**WELWYN HATFIELD BOROUGH COUNCIL
EXECUTIVE DIRECTOR - PLANNING, PUBLIC PROTECTION AND GOVERNANCE**

DELEGATED APPLICATION

Application No: 6/2021/2791/HOUSE
Location: 28 Theobalds Road Cuffley Potters Bar EN6 4HQ
Proposal: Conversion of loft to habitable space including roof alterations, the addition of side dormers and the erection of a part first floor and part single storey side and rear extension
Officer: Ms Emily Stainer

Recommendation: Granted

PROPOSED ATTIC FLOOR PLAN
Scale 1:50

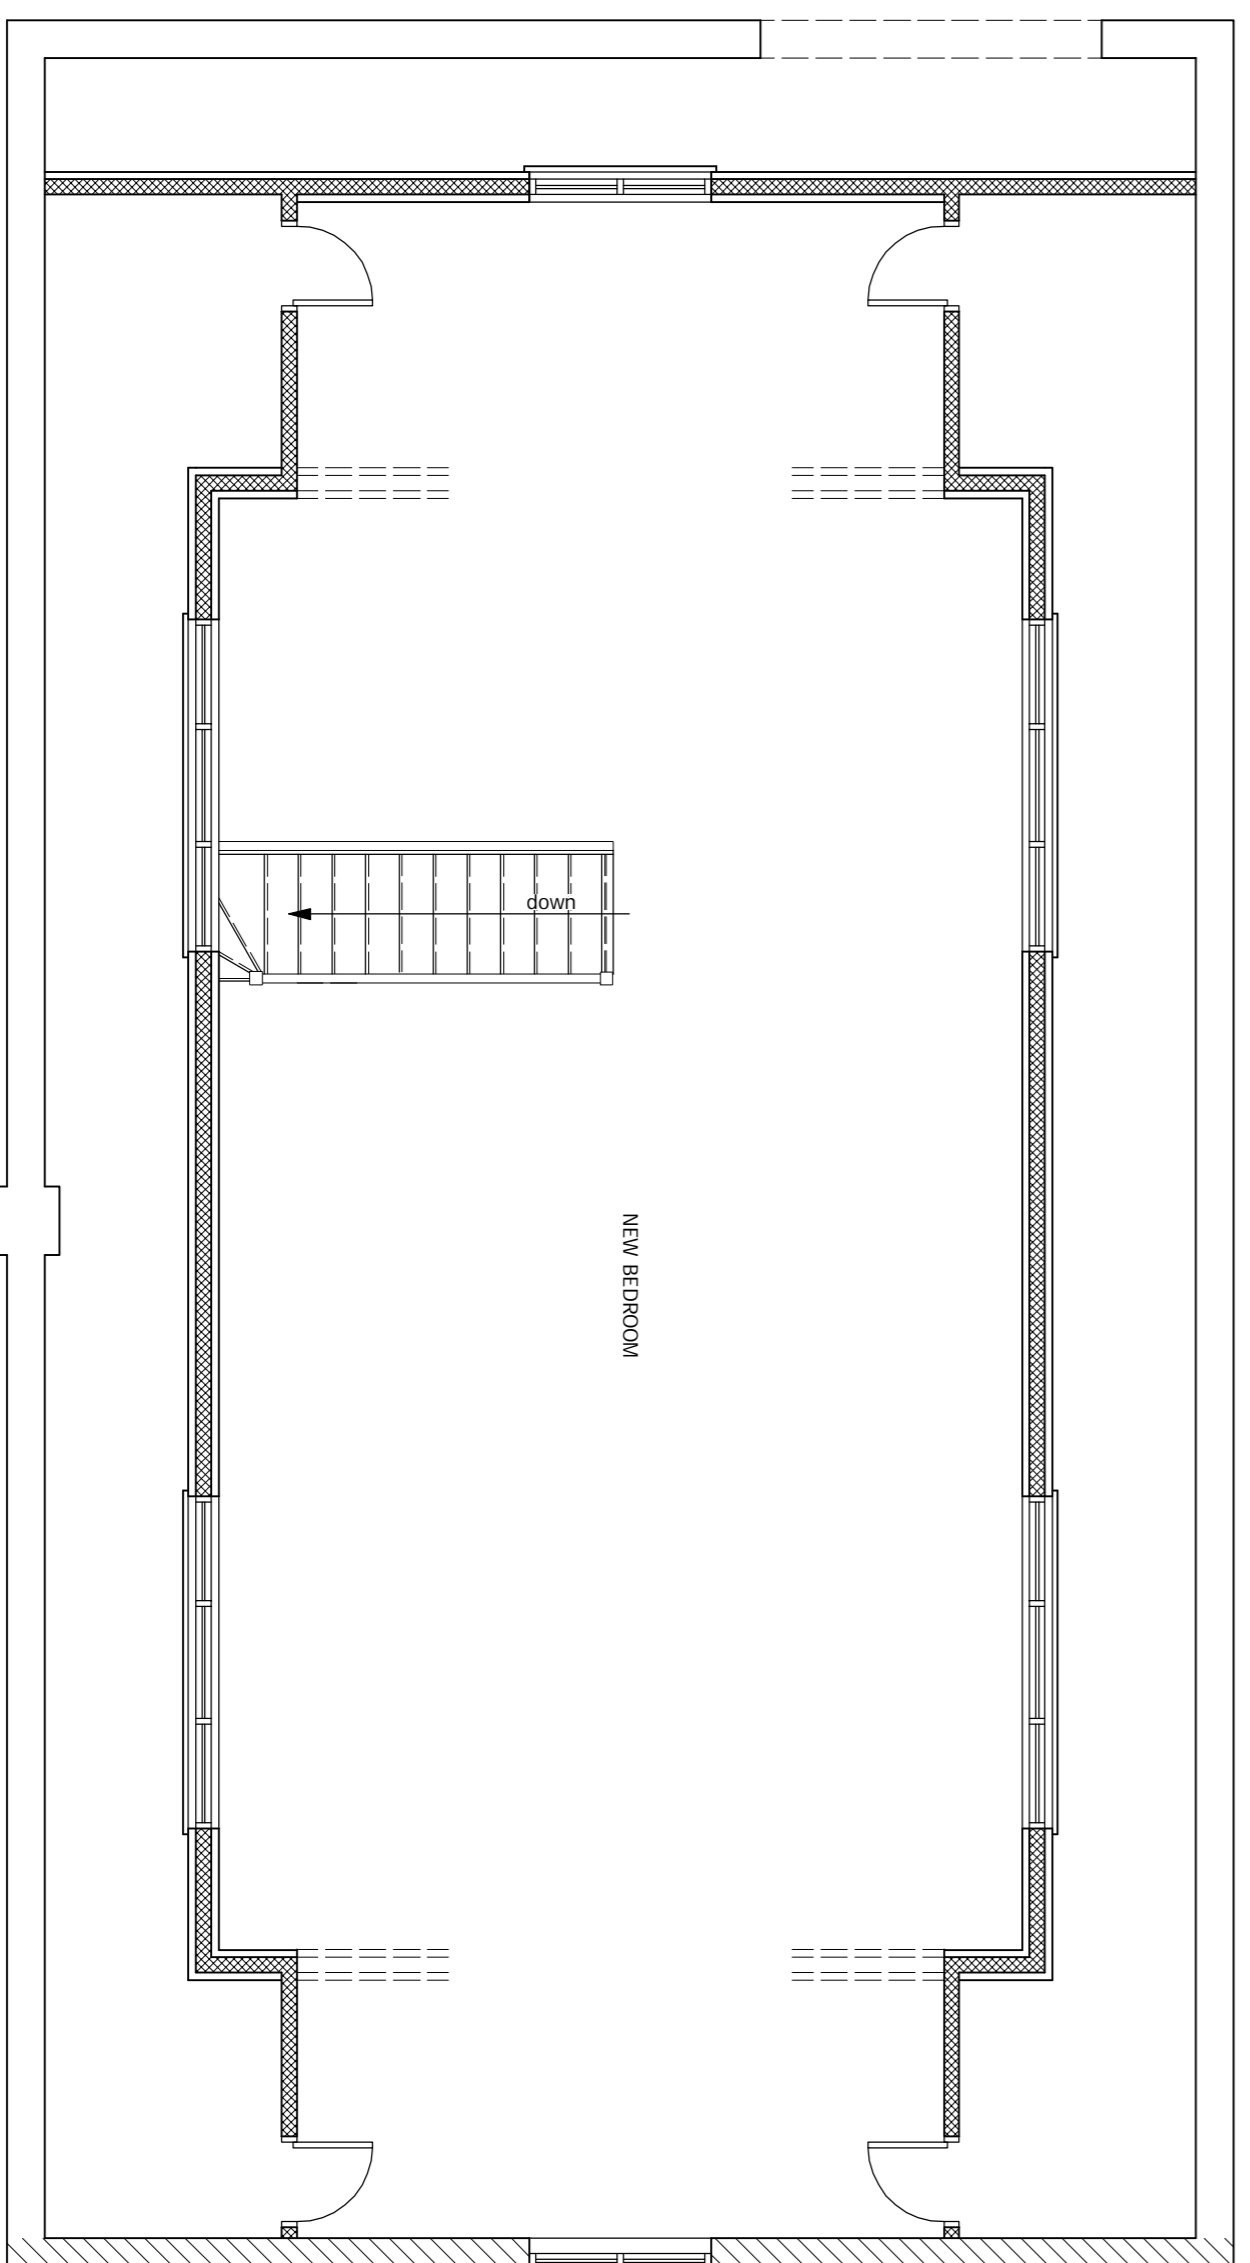
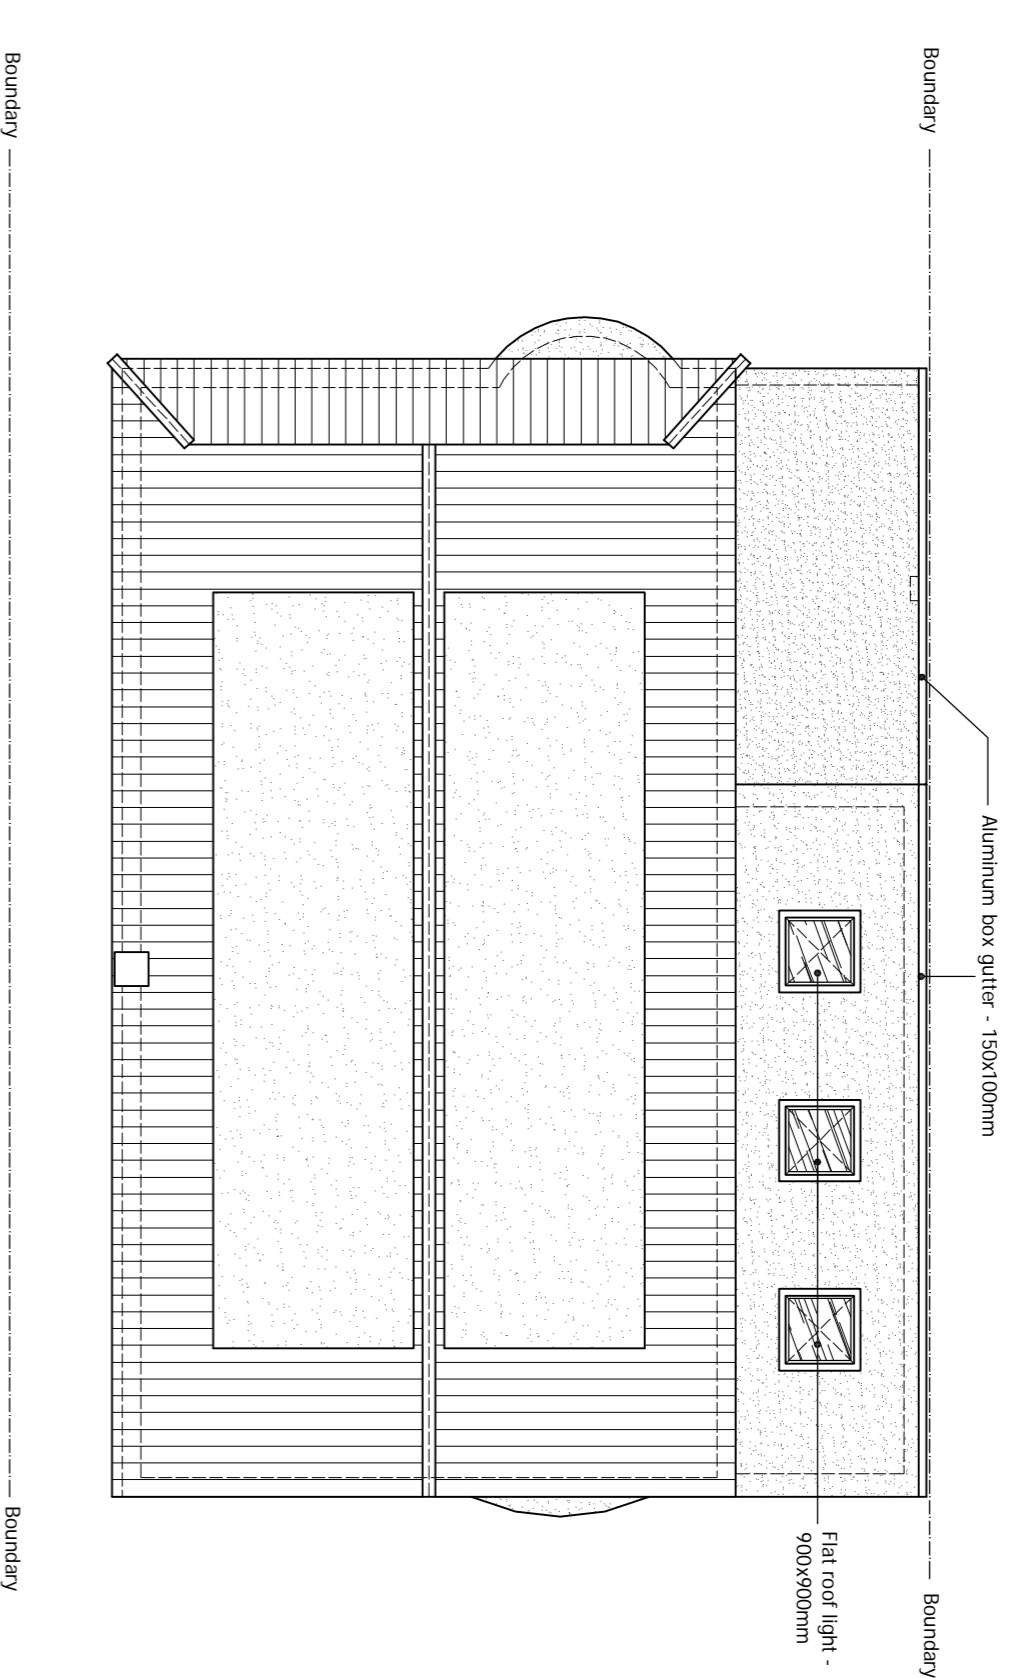
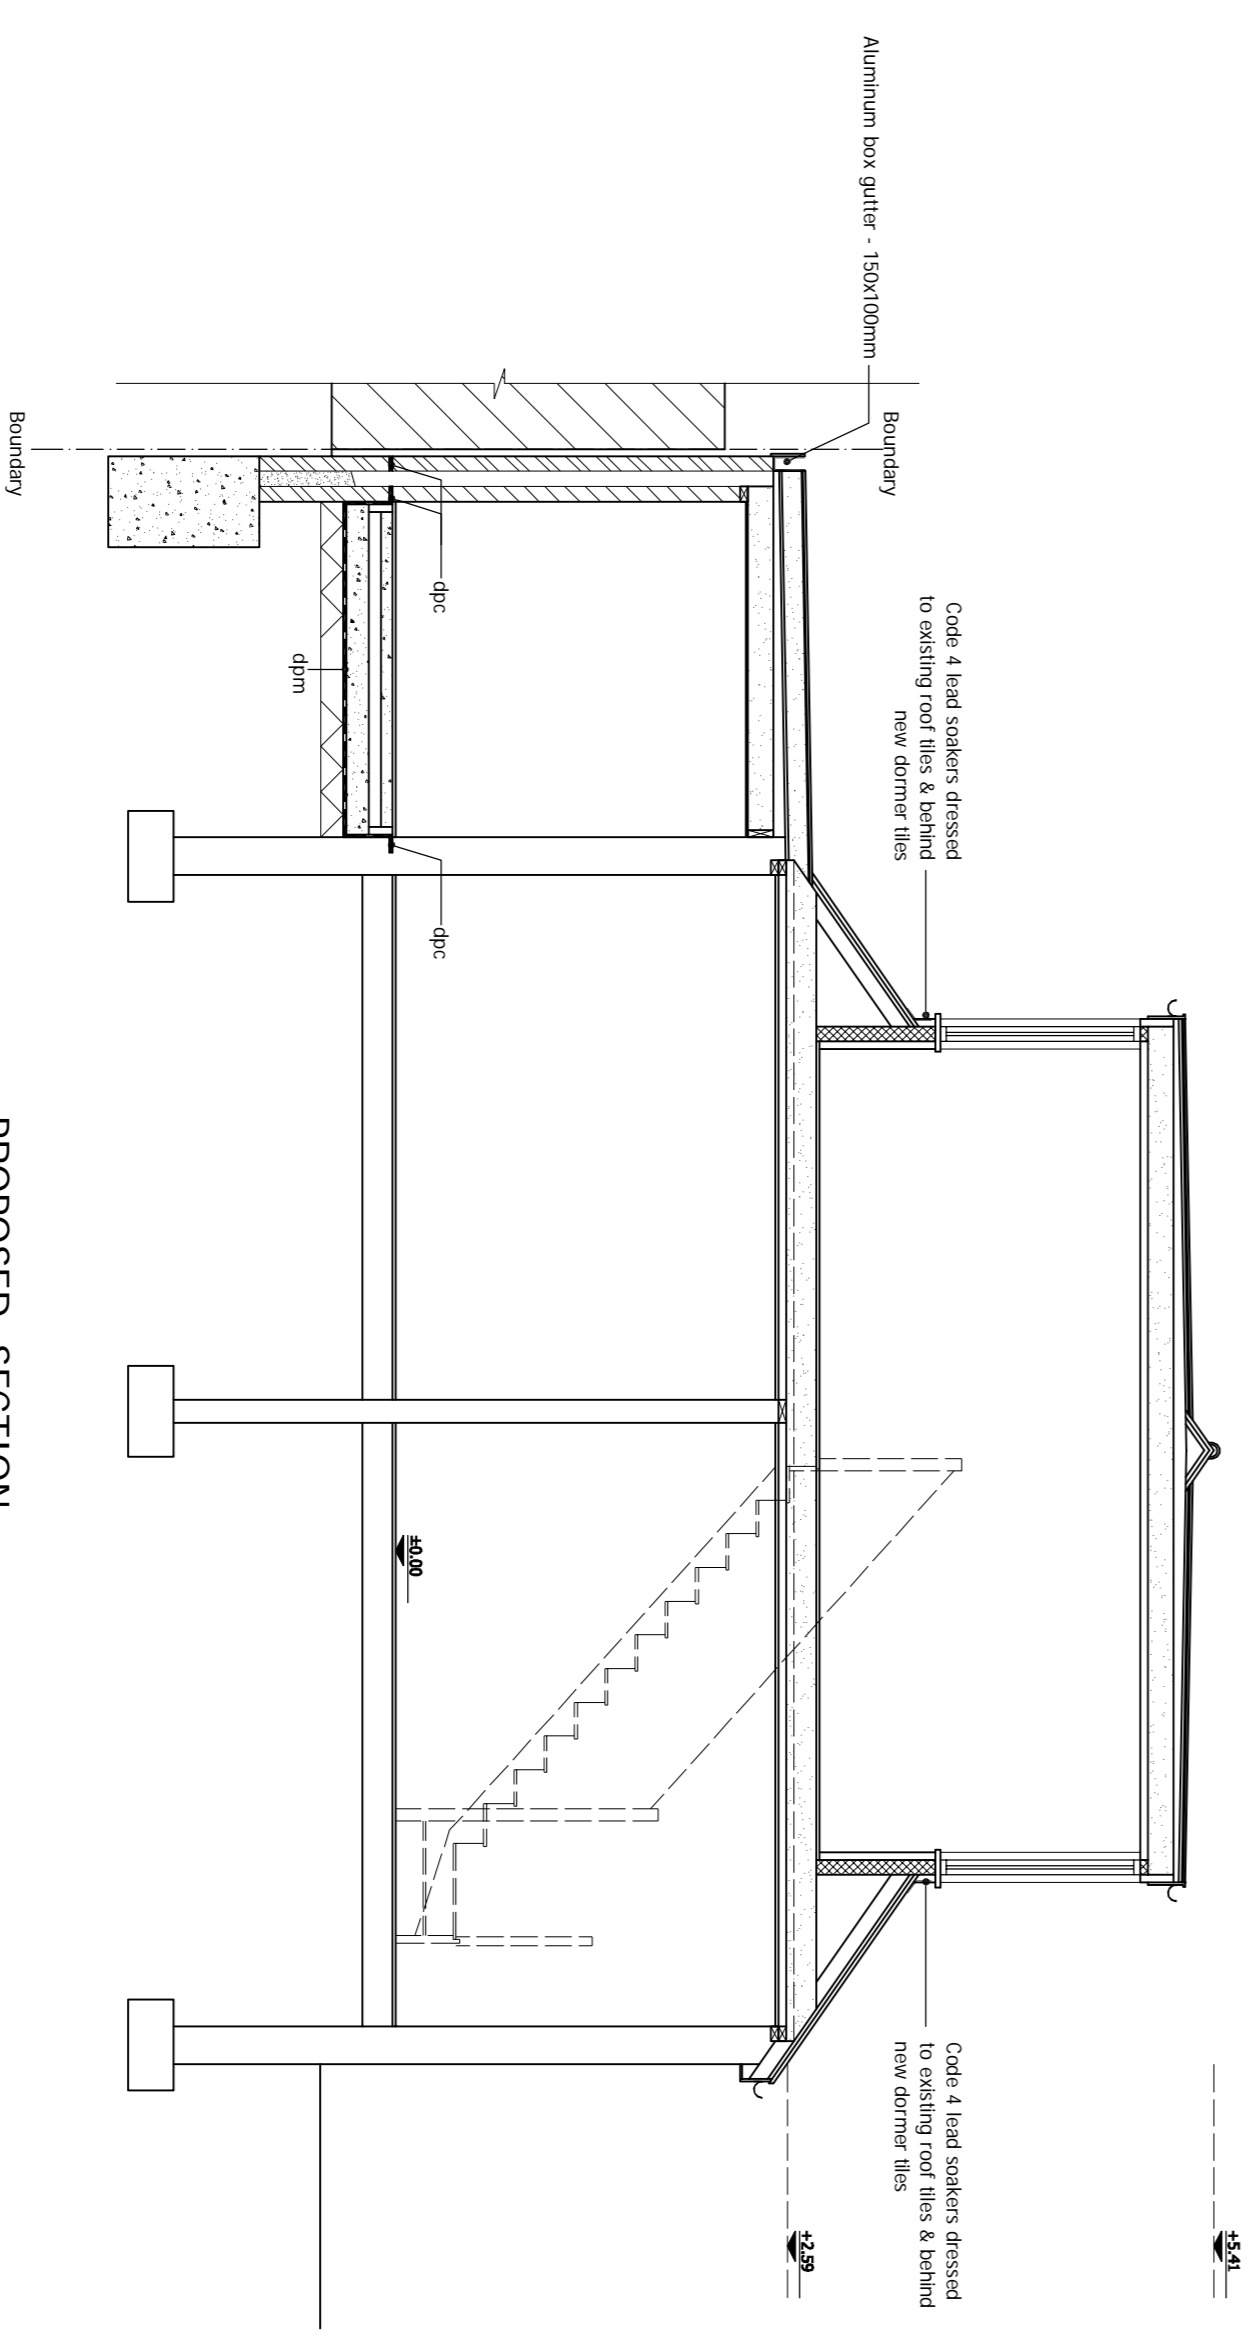
dormers were proposed on each side of the building, each with two windows. The combined width of the initial dormers on each side would have been approximately 11.8m (5.9m in width) and a height of approximately 1.8m. The amended design includes a single dormer on each side which would measure approximately 10m in width and would be set in from the front and rear of the roofslope by at least 1m. Each dormer would only benefit from two windows and they have been reduced in size from the previous proposal in order to integrate better with the fenestration pattern on the existing house. The amended design is considered to be more appropriate to the existing dwelling and to the context in the surrounding street scene. The plans state that roof tiles, brickwork and render will match existing but there are limited details in respect of window/door materials. Therefore, a condition will be imposed which ensures the materials match existing.

The neighbours either side of the application property (26 and 30 Theobalds Road) both submitted comments on the original proposal. Both properties have previously been extended in the past. The comments submitted refer to a loss of privacy and light from the proposed dormers and the design of the original dormers, including that there should be a reduction in the length of dormer windows at the rear of the property and the distance from the rear wall to the dormer should be a minimum of 1350mm. As the amendments to the design include a reduction in the overall size of the dormers and less windows are proposed than before, it has not been necessary to re-consult neighbours. However, it is worth noting that the single dormer on each side of the property now maintains a distance of approximately 1.9-2m from the front and rear of the property and the side windows are labelled as being obscure glass with a non-opening area below 1.7m above the finished floor level. This overcomes some of the points raised in the comments.

2. Any upper floor window located in a wall or roof slope forming a side elevation of the building hereby approved must be obscure-glazed and non-opening unless the parts of the window which can be opened are more than 1.7 metres above the floor of the room in which the window is installed, and shall be retained in that form thereafter.
